Our ref: MP06_0228-Mod-30

Subject: Request for Additional Information for the Shoalhaven Starches Expansion (MP06_0228-Mod-30)

Figure 2. Proposed Plant Layout – Supagas 220 Bolong Road, Bomaderry, NSW (source: Supagas Pty Ltd GLPP16027-L1-008)

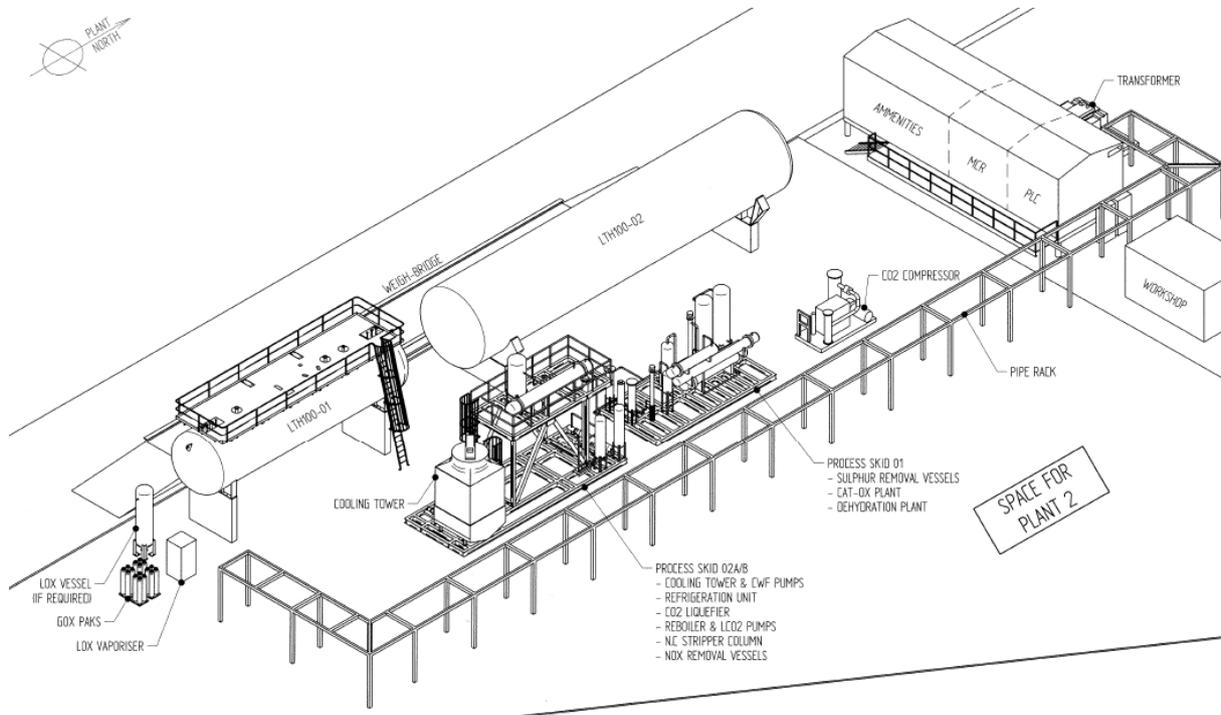
1. The provided noise assessment has considered the expanded Supagas facility against the noise limits set Environment Protection License (EPL) no. 21178. While it is acknowledged this EPL applies to the operation of the Supagas facility, the subject development consent, as amended, also sets noise limits for the entire Shoalhaven Starches facility under Schedule 3, condition 12 which the modification must have regard to.

As such, please update the noise assessment to undertake a cumulative assessment of the proposed facility in the context of existing and approved operations, demonstrating that the modified development can continue to meet the consent's noise limits.
